# Summary of Comments on TIA Redlines Oct 2020 With LSC Response.pdf

Author: dsdrice    Subject: EPC ENG Review    Date: 10/11/2020 8:21:15 PM -06'00'

Figure 1

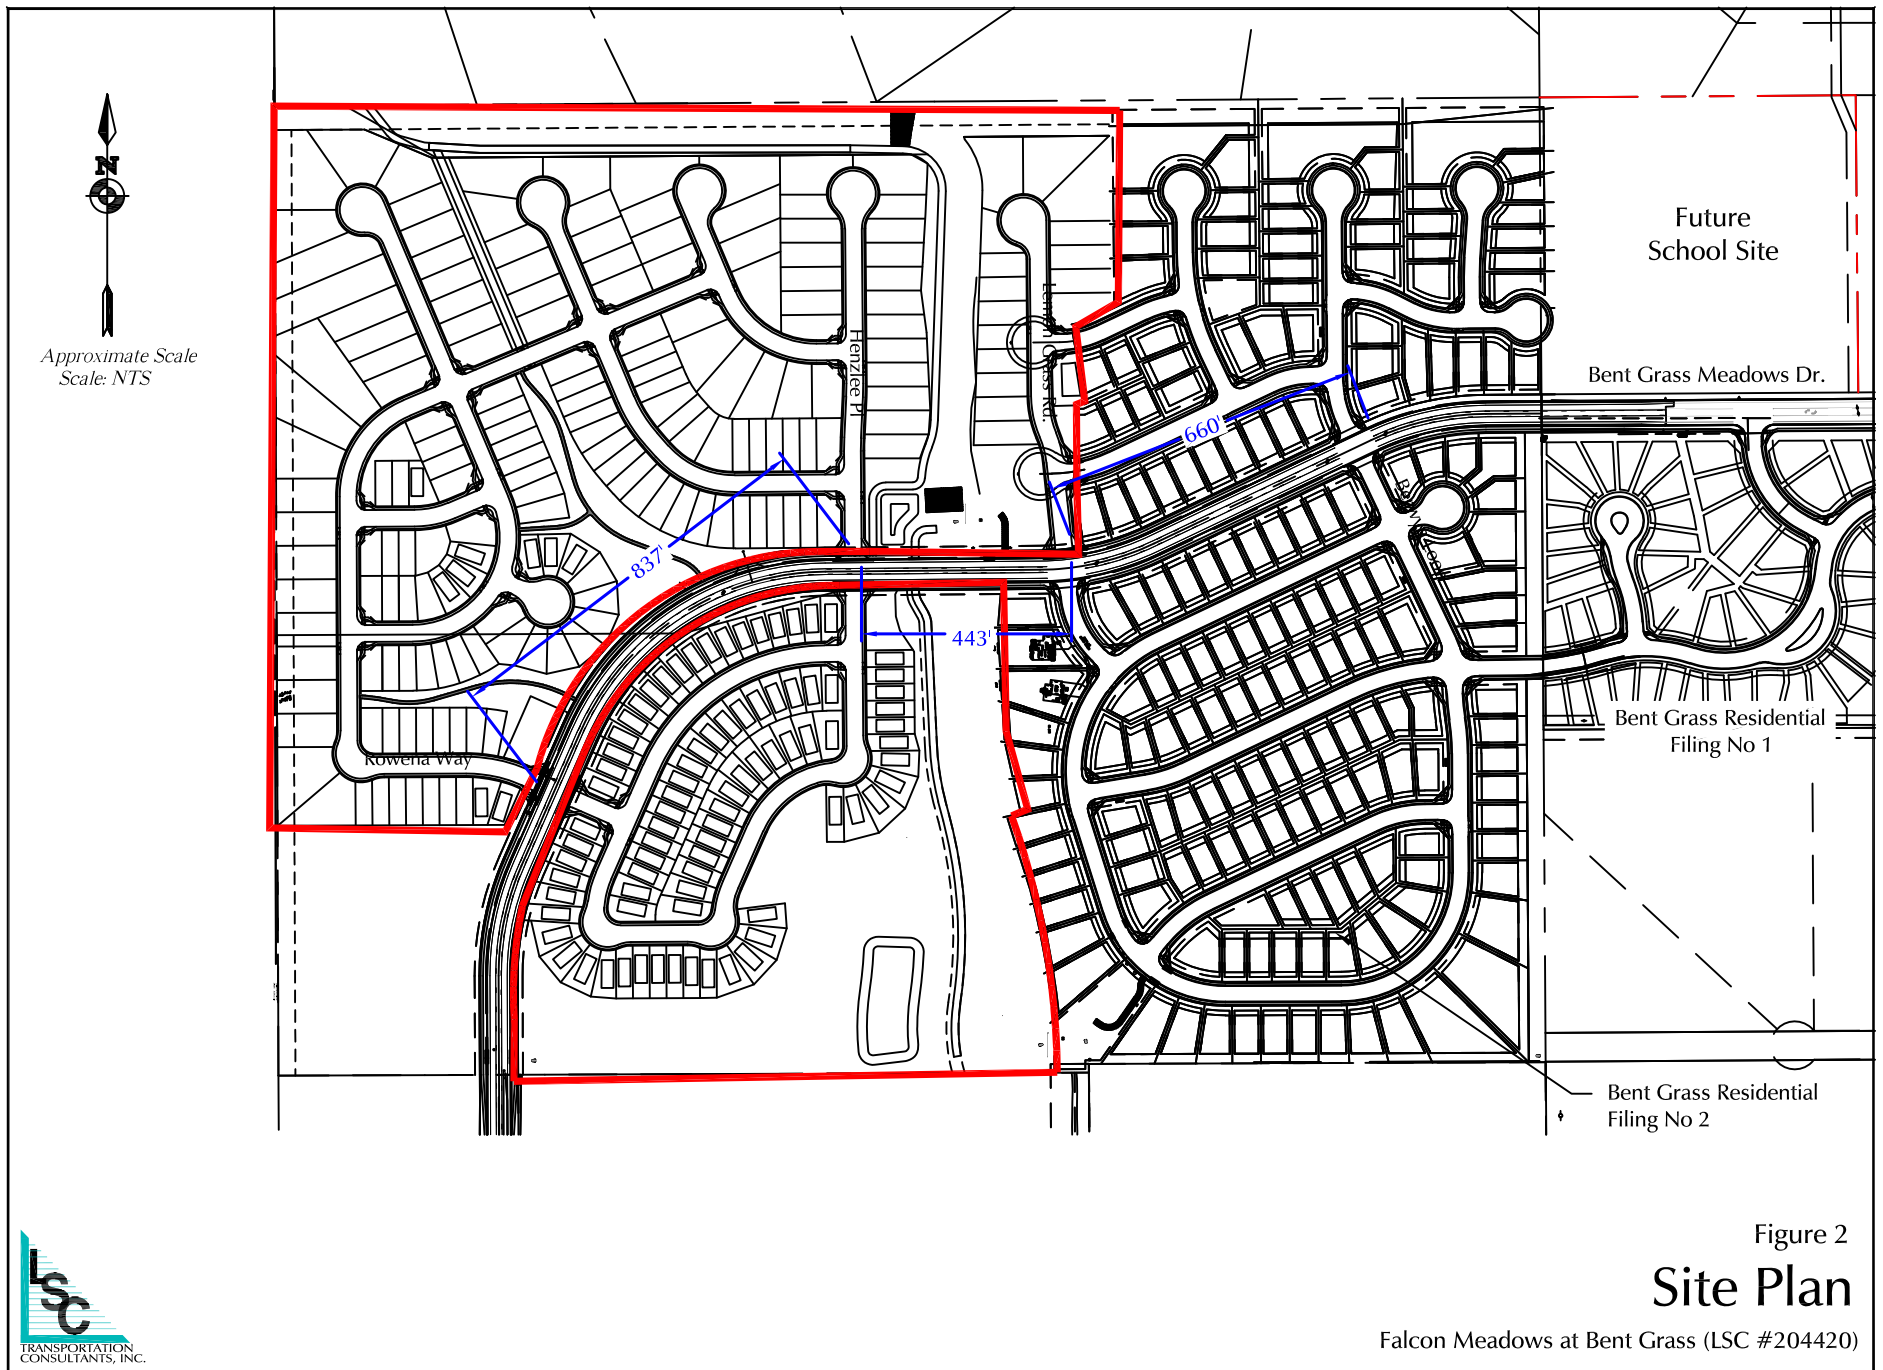
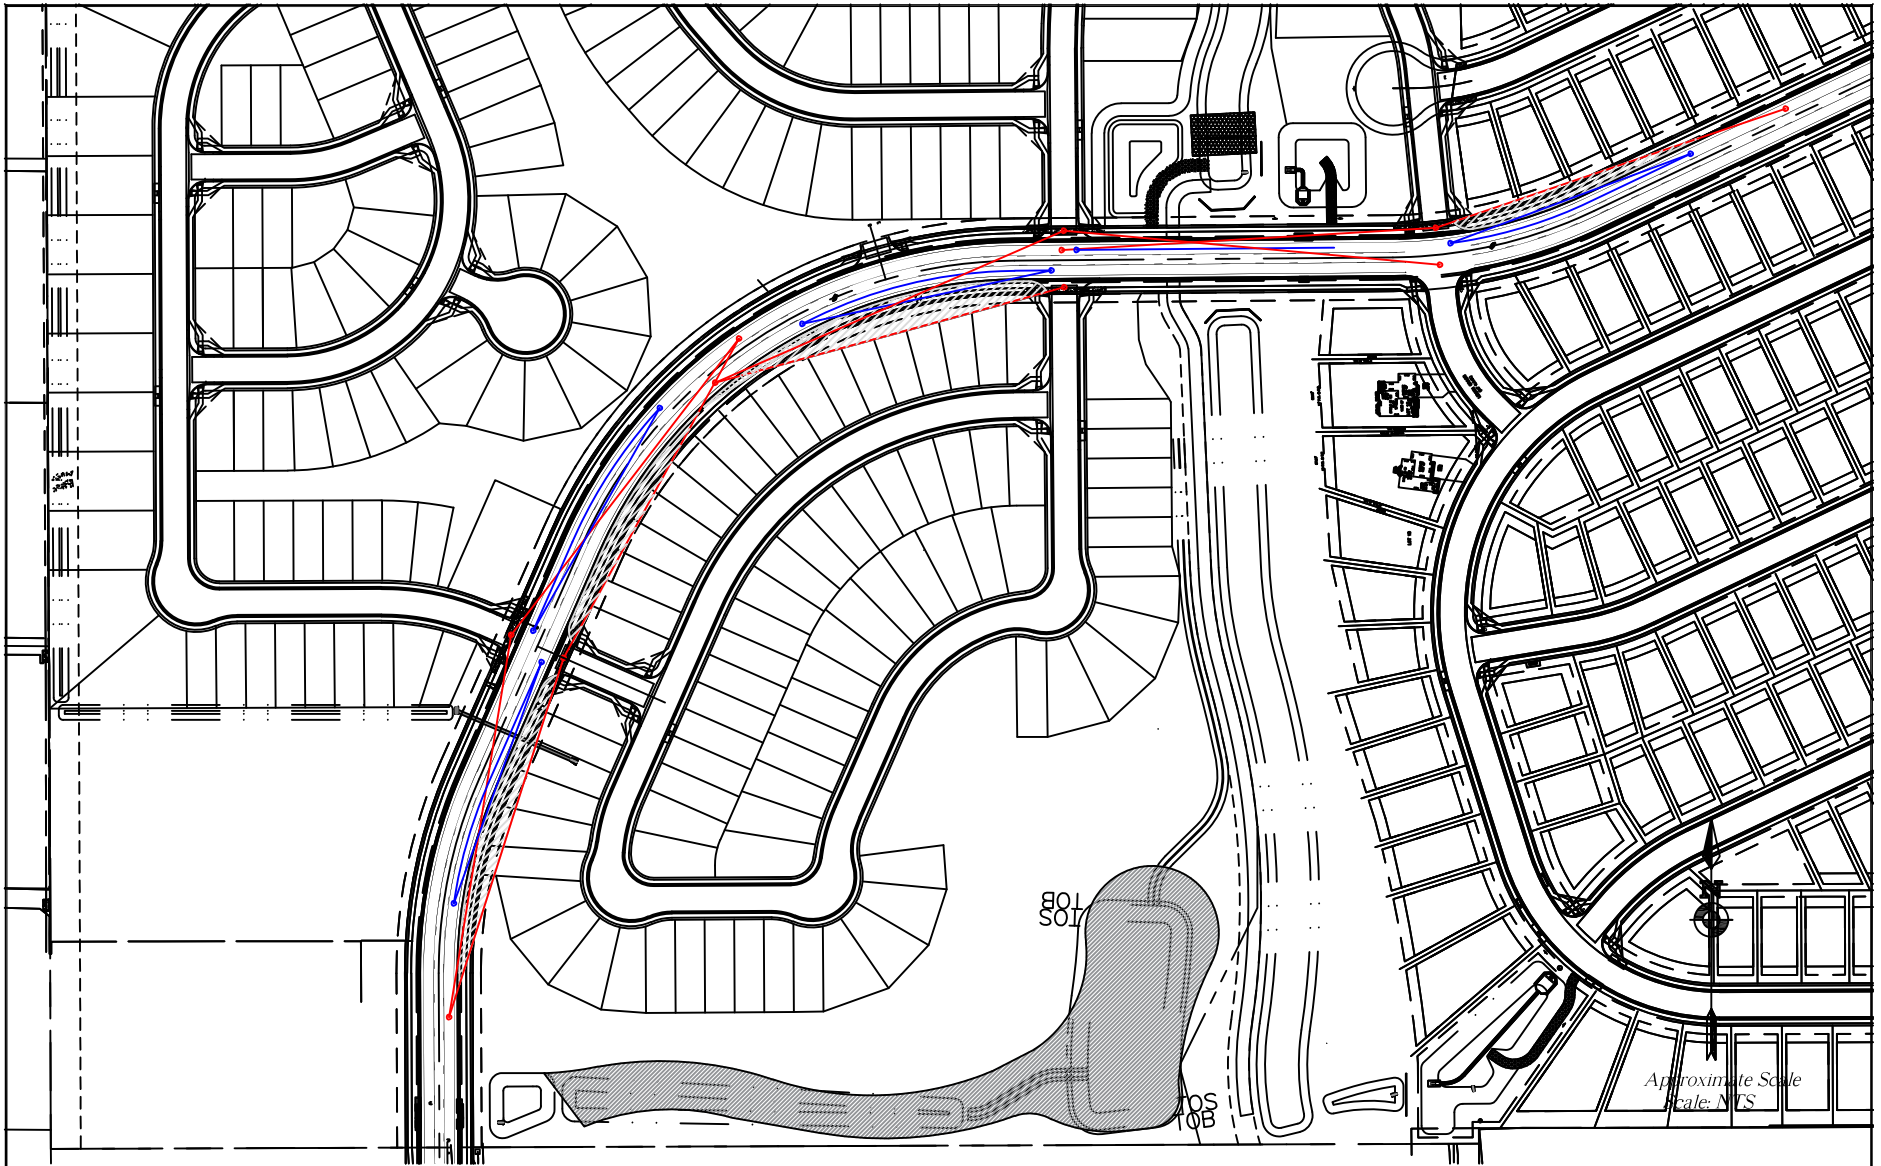
Label road names - Lemon Grass, Berwyn, Lynch, Kittrick, Rowena, Hanzlee, Sea Oats, Avena...

Author: Kirstin    Subject: Sticky Note    Date: 12/1/2020 2:41:57 PM  
The road names have been labeled as requested
